Fwd: Planning Application for 1 Coleridge Way (Ref: 6160/APP/2019/3638)

Subject: Planning Application for 1 Coleridge Way (Ref: 6160/APP/2019/3638)

We have been appointed by the London Borough of Hillingdon (LBH) to undertake validation checks on planning applications submitted to them. We are currently validating the above application, and would advise your current planning application has been made invalid for the following reasons:

EAST / SIDE TO LARGE VERGE. VIEW X

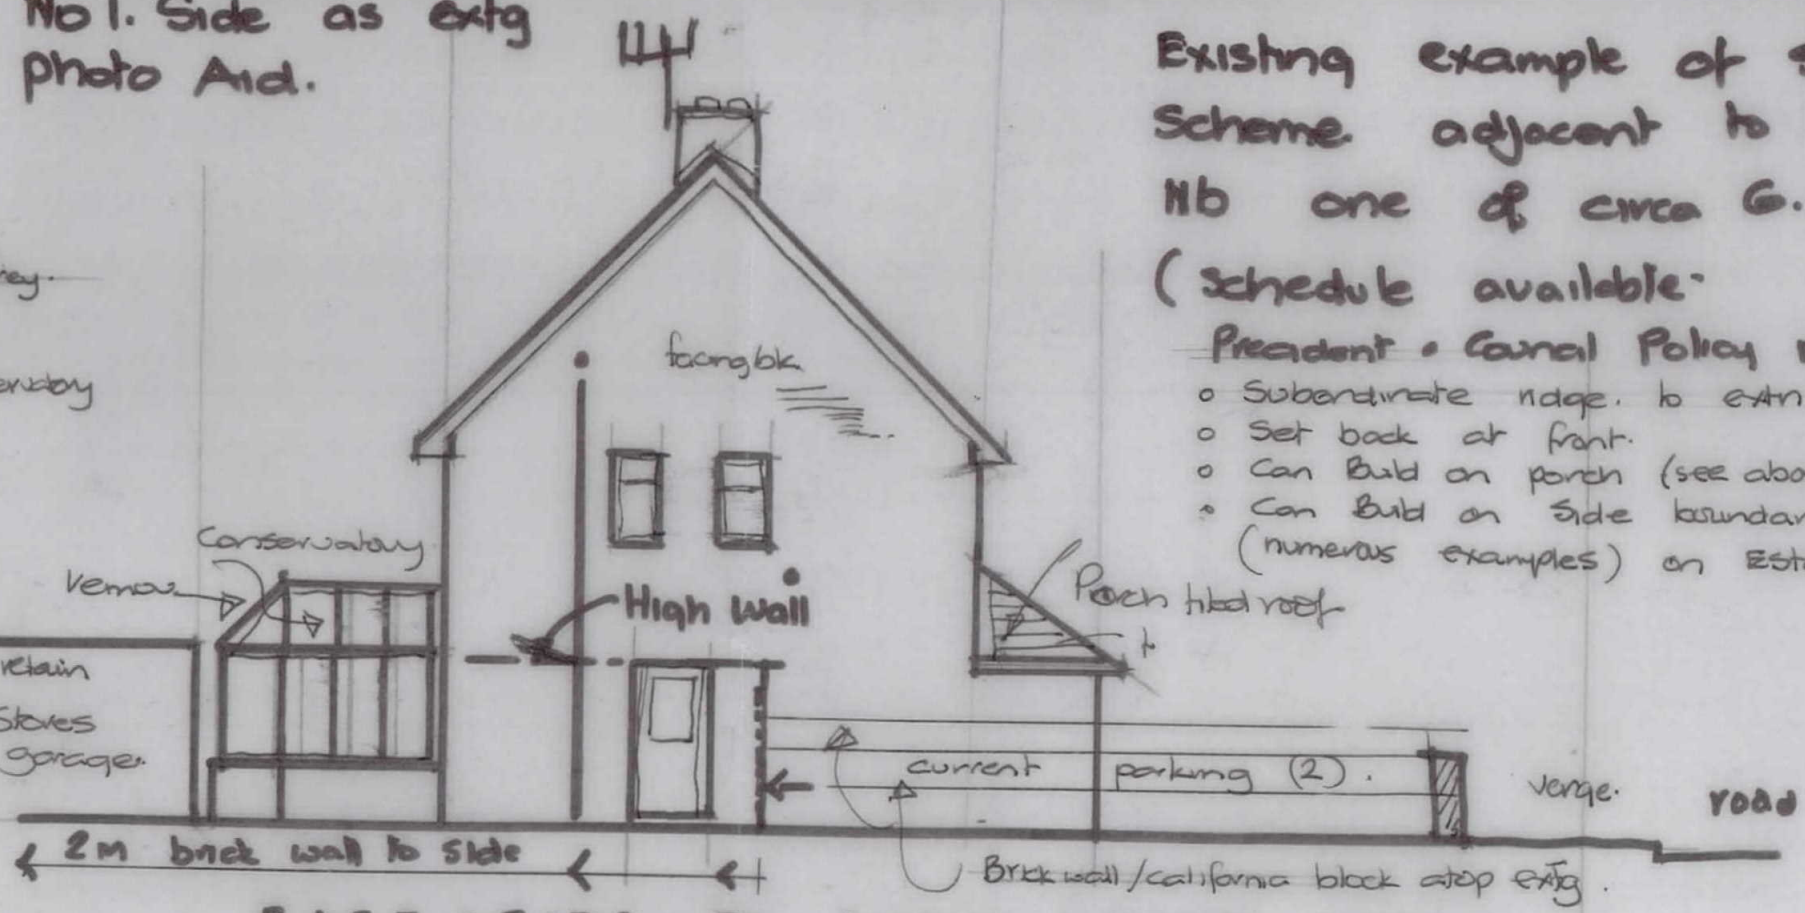
1. Plans Inconsistent: The depth of the extension is inconsistent between the floor plans and east elevation. Please review and amend accordingly; ✓

2. Plans Inconsistent: The window is inconsistent between the proposed first floor plan and east ✓

elevation. Please review and amend accordingly.
